I am writing as a parent of a child that attends Darlington Public School regarding the proposed development by the University of Sydney, MP 07_0158 – Abercrombie Street Precinct, Syd Uni. Darlington Public School is an inner city school servicing the suburbs of Chippendale, Darlington and parts of Redfern. The school is directly adjacent to the western border of the project.

Drawing title
BASEMENT FLOOR PLAN

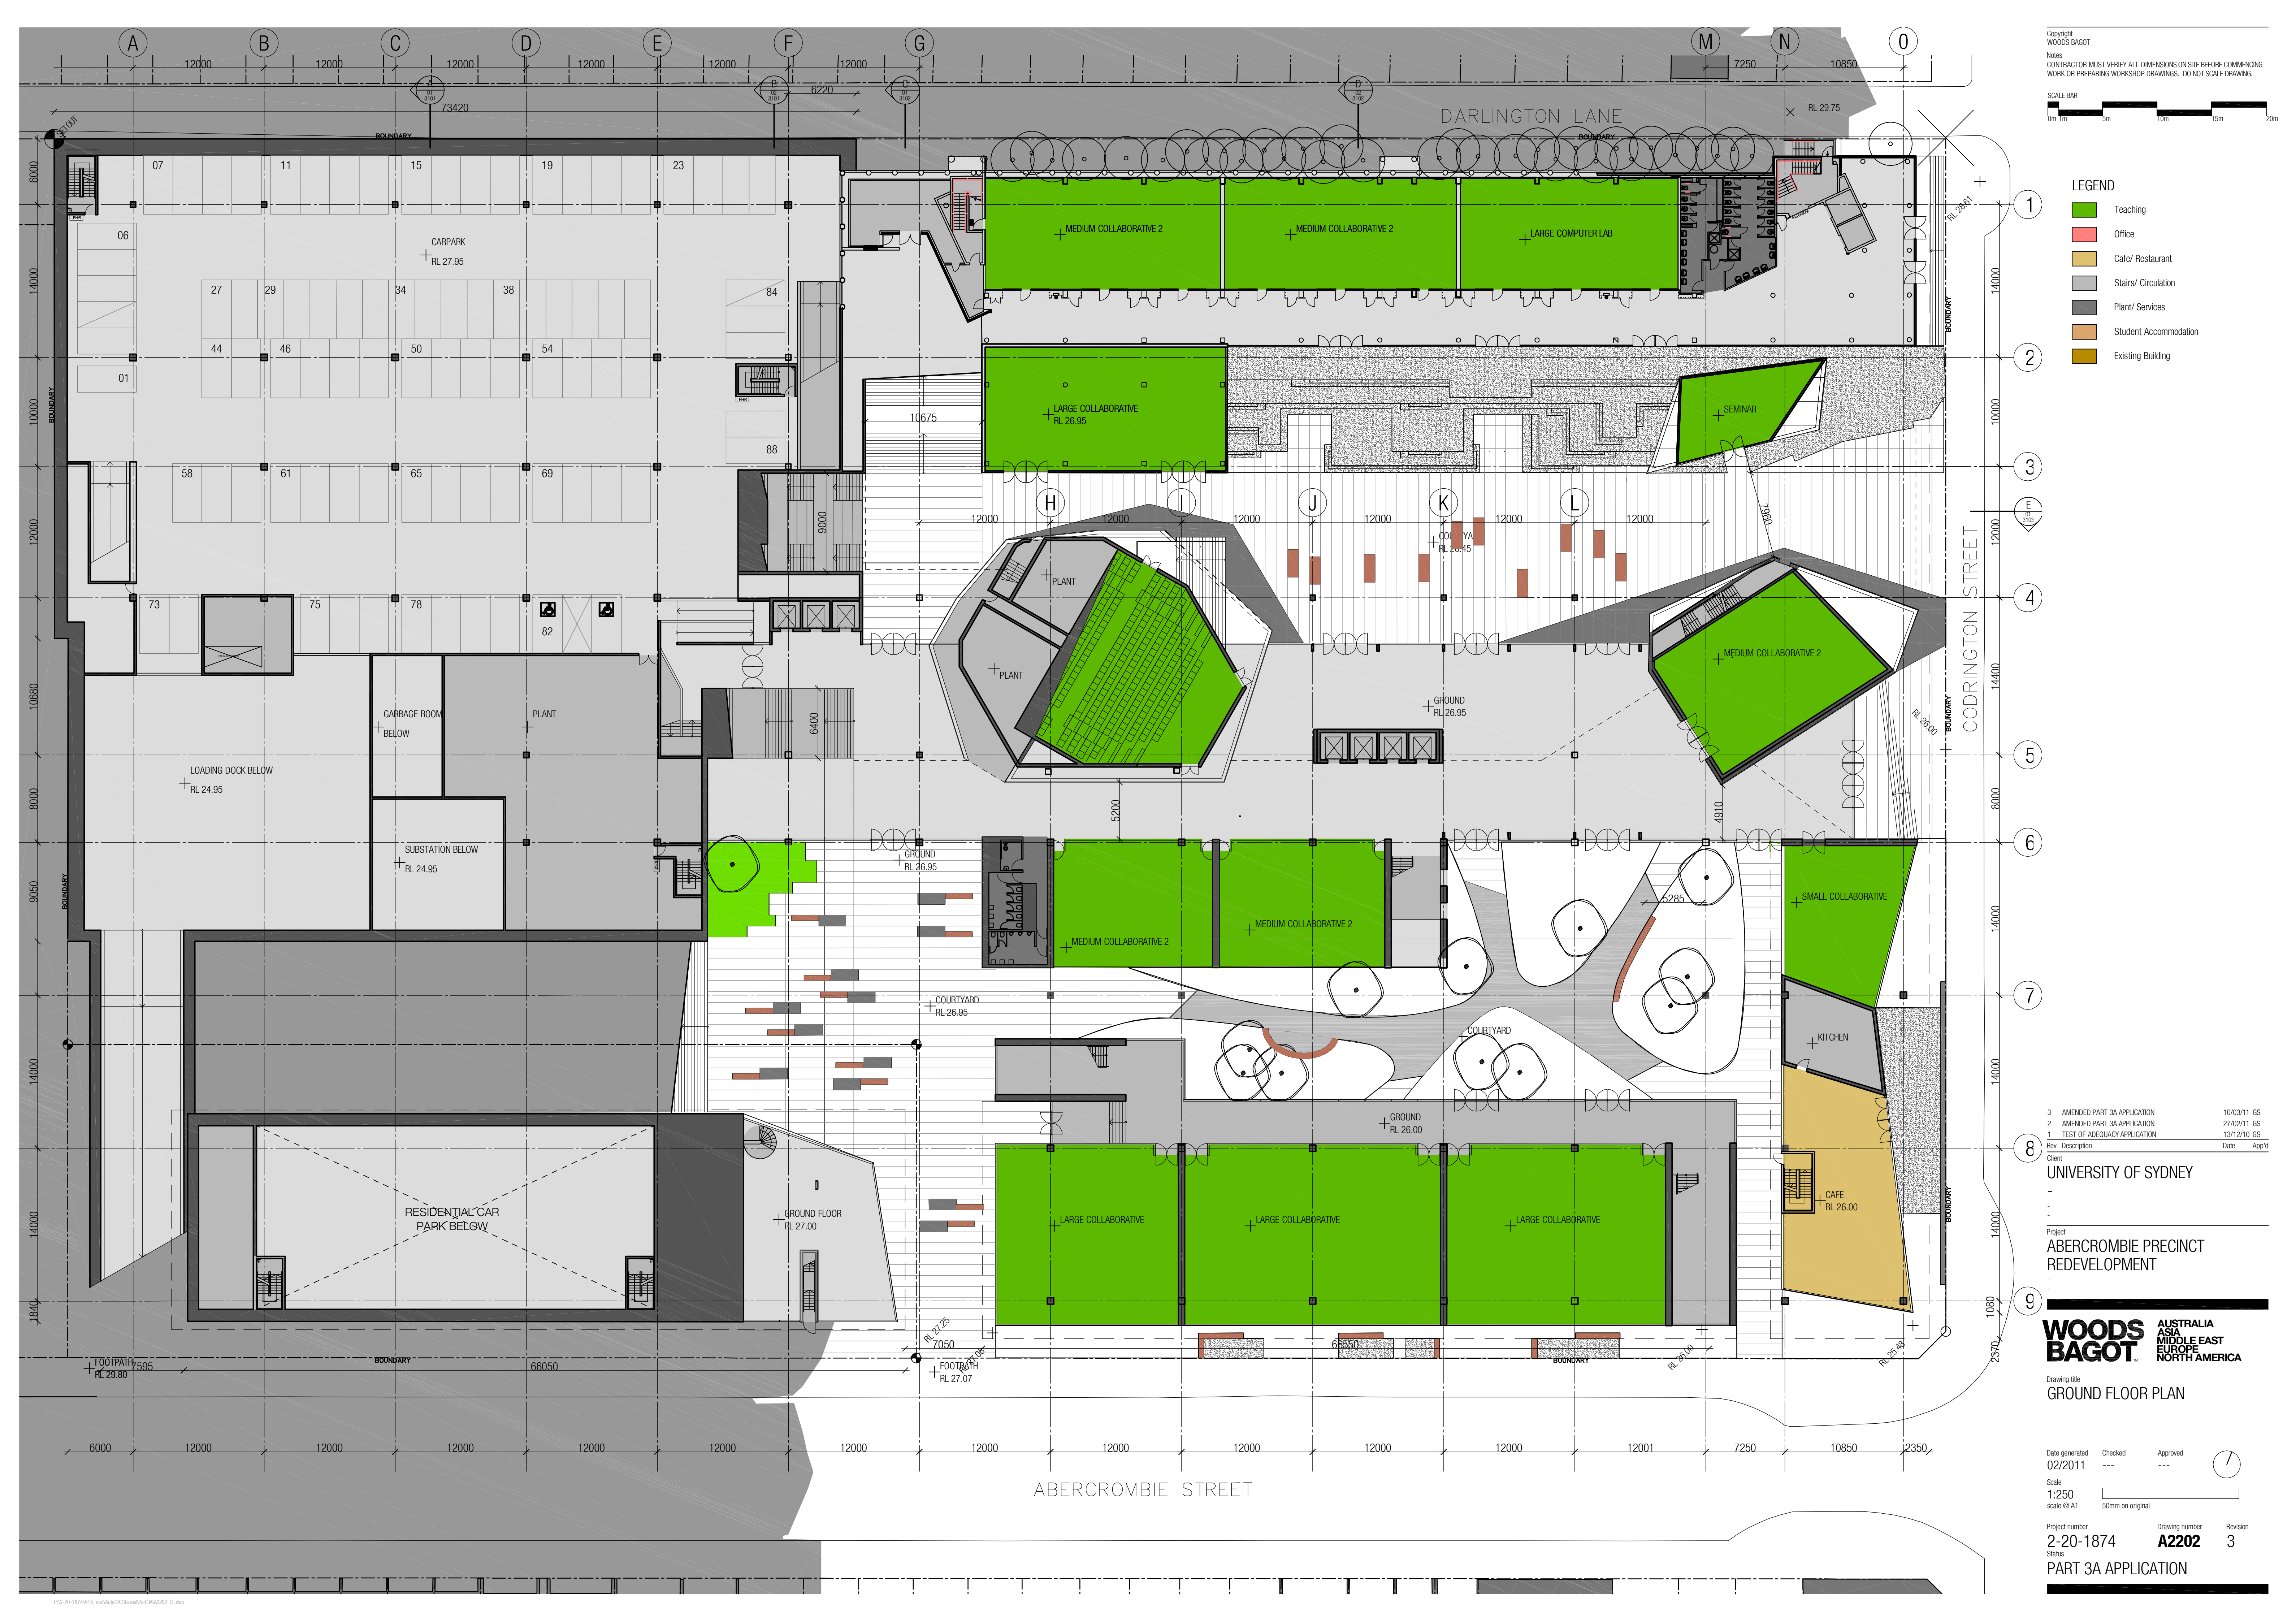
As per the current development plan, the proposal calls for an underground car park to be built for the student accommodation and University staff. The car park will accommodate 185 car spots, and its entrance will be on Abercrombie Street, at approximately the same point of the construction access.

The concerns raised above about the access point to the construction site are the same for this car park access point increasing the risk to school children's safety, in an area that has already been highlighted through the respective organisations (Council, Police, and RTA). The increased traffic flows and access point are an unacceptable risk to the children who attend the school. There is no justification for this level of risk to a school community, particularly as the University has another street frontage without school or residential issues (the University being the only stakeholder for Codrington Street) and an access street internal to project (Darlington Lane).
